REVISION RESPONSE LETTER

**RE: Tenenit Investment, LLC
File Number COM-20-067**

DATE: December 4, 2020

1 of 10
SITE PLAN

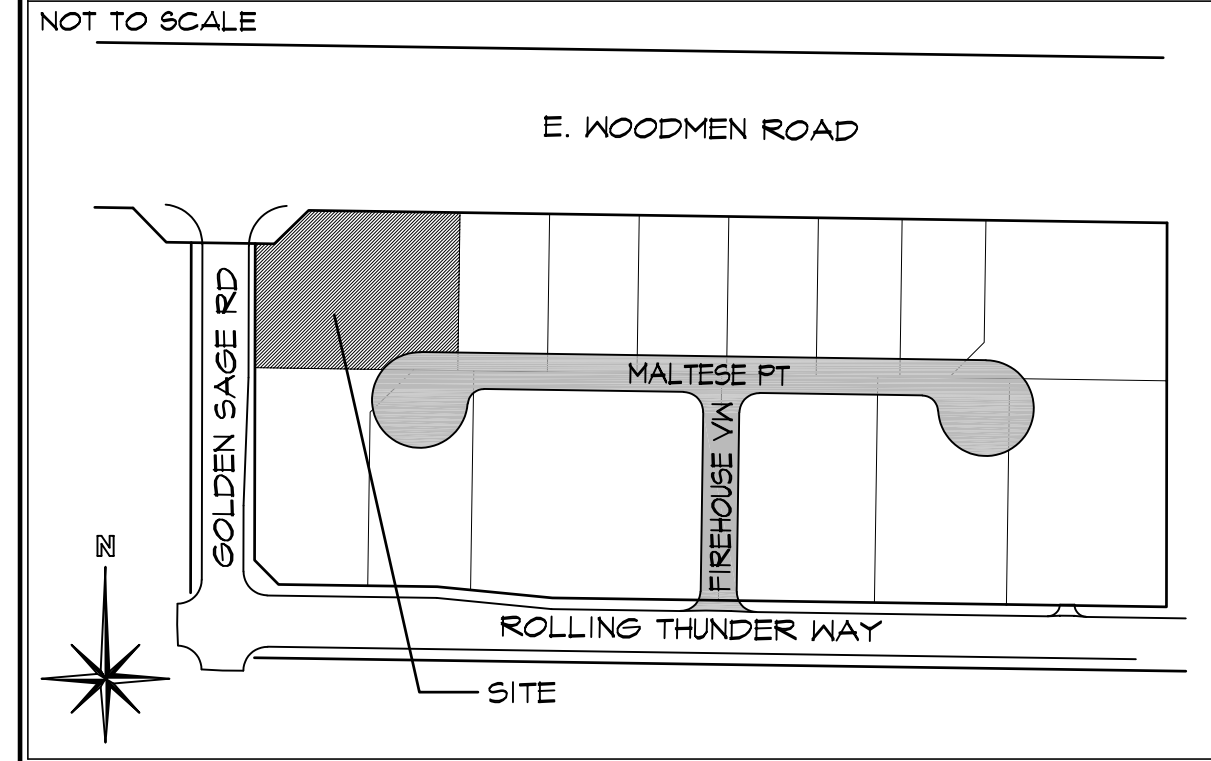
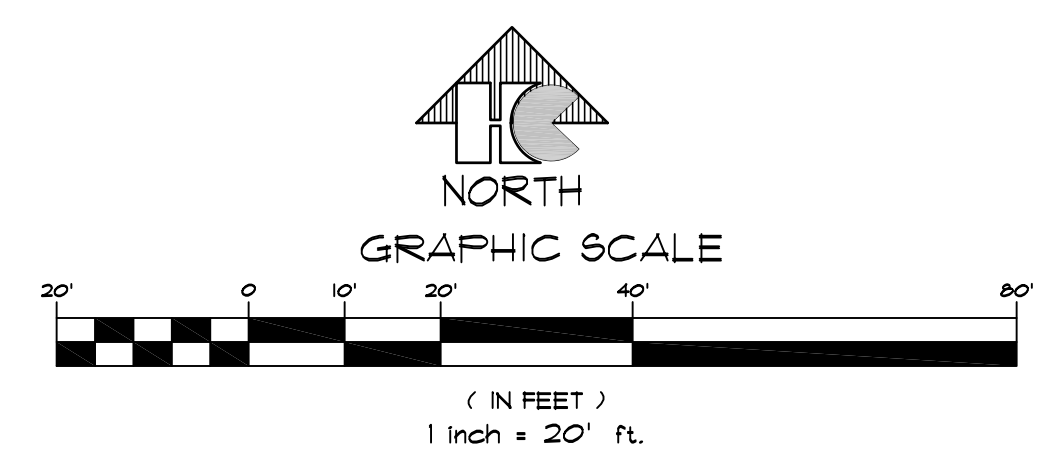
3. Provide Bike Rack per Code. **Provided.**
4. Provide Bike Rack Detail. **Provided.**
5. List Bike Parking Required and Provided. **Added.**
6. Label dimensions of parking spaces (Typical). **All existing parking spaces are 9'-0"x18'-0" Typical.**

7. Accessible path to the entrance? This does not look wide enough to go from access aisle to door. **The path from the van accessible space is 3'-9" and then widens to 4'-8"; which meets the ADA requirement. This is not a sidewalk it is an existing apron which is a level surface to the existing asphalt. The hatched area is painted as crosswalk area to have a walkway space out of the way of traffic.**

8. Is the Auto repair business still utilizing this half of the building? If so, that should reflect in the parking calcs etc. and site data table. **Yes, they are utilizing half of the building and the information has been added.**

9. Uses should match those on the PUD: Brewery (Light Manufacturing) and whatever is in the other half of the building. **Uses have been revised. 5,000 sf of the existing building will continue to be used for Auto Repair. The other 5,000 sf of the building was most recently used as a gymnastics facility which has been noted. The intent is to permit this half to be used as a brewery per the floor plan provided. The brewery use falls under the light manufacturing use of the EPC zoning and is an approved use.**

10. Add County file No COM-20-067. **Added.**
